Engineers Comments Regarding Surface Water Drainage

Application No: WA/3/21/HH

Site Address: Ashogle Eastergate Lane Walberton BN18 0BA

Description of Works: Single-storey rear extension to detached dwelling.

Block Plan

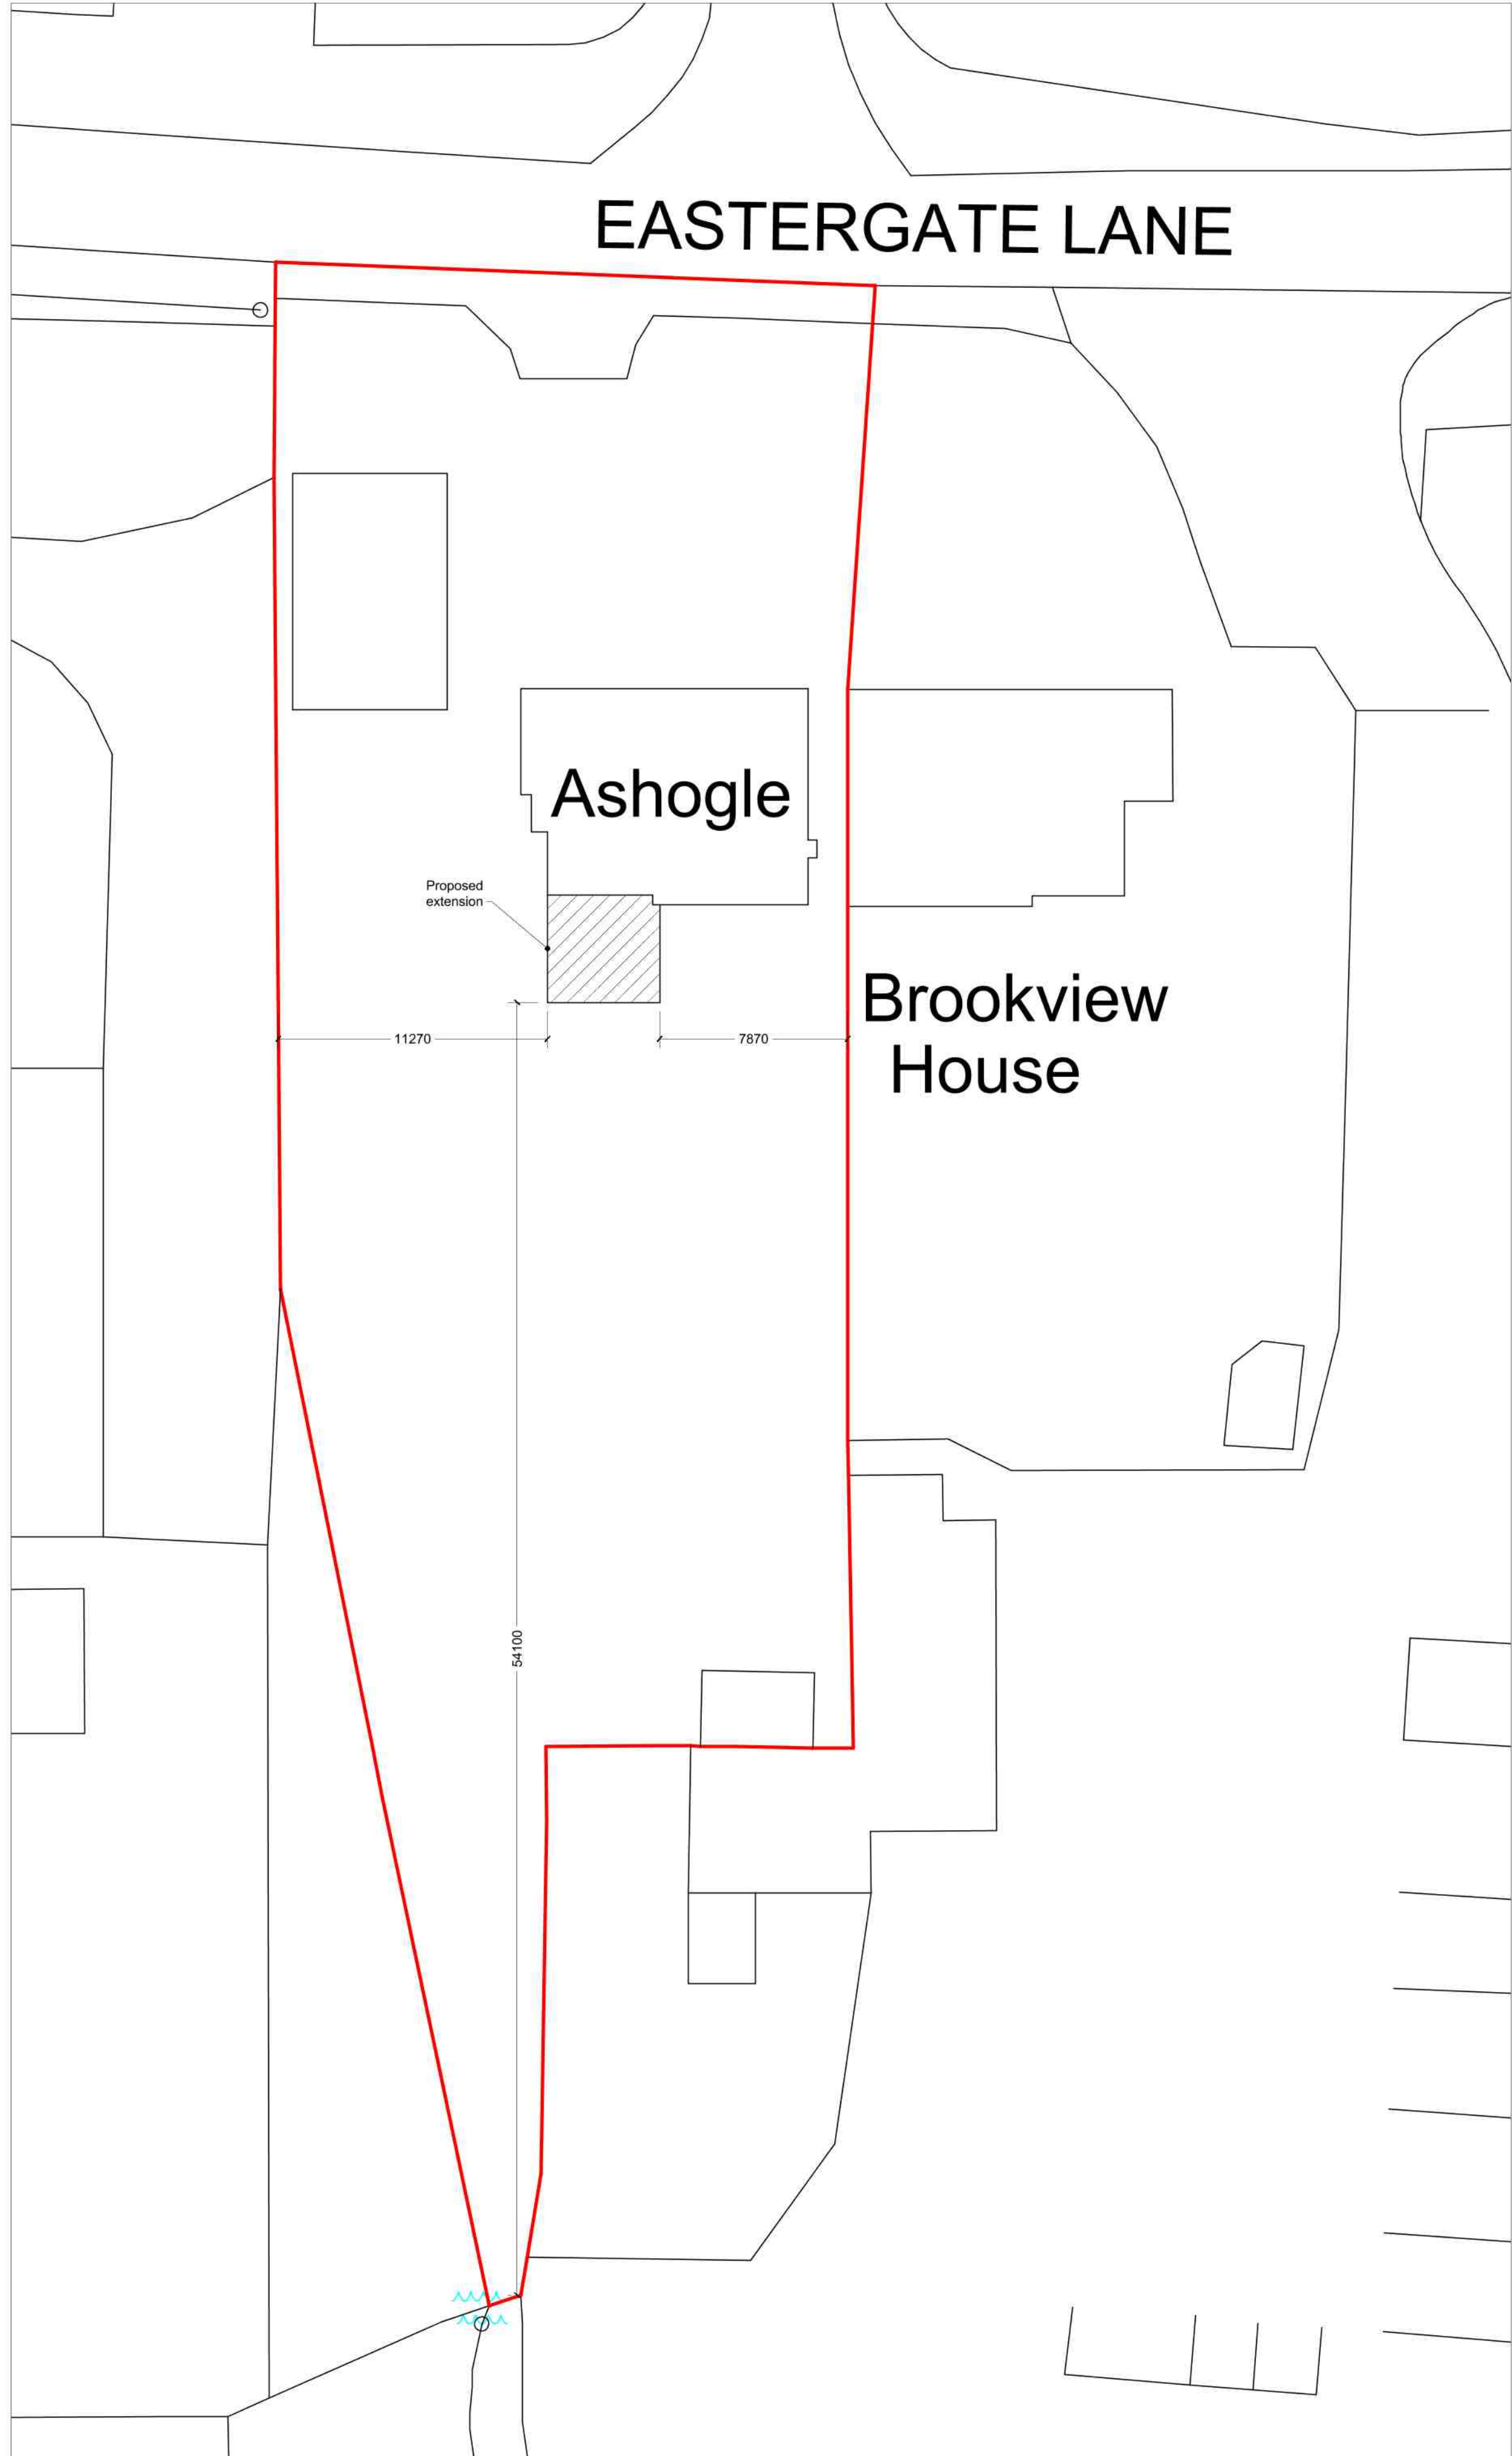
As the proposed development is within the Lidsey Treatment Catchment, standard condition PCENG2 would have been requested. The applicant should also be aware of culverts running along the western boundary of the site.
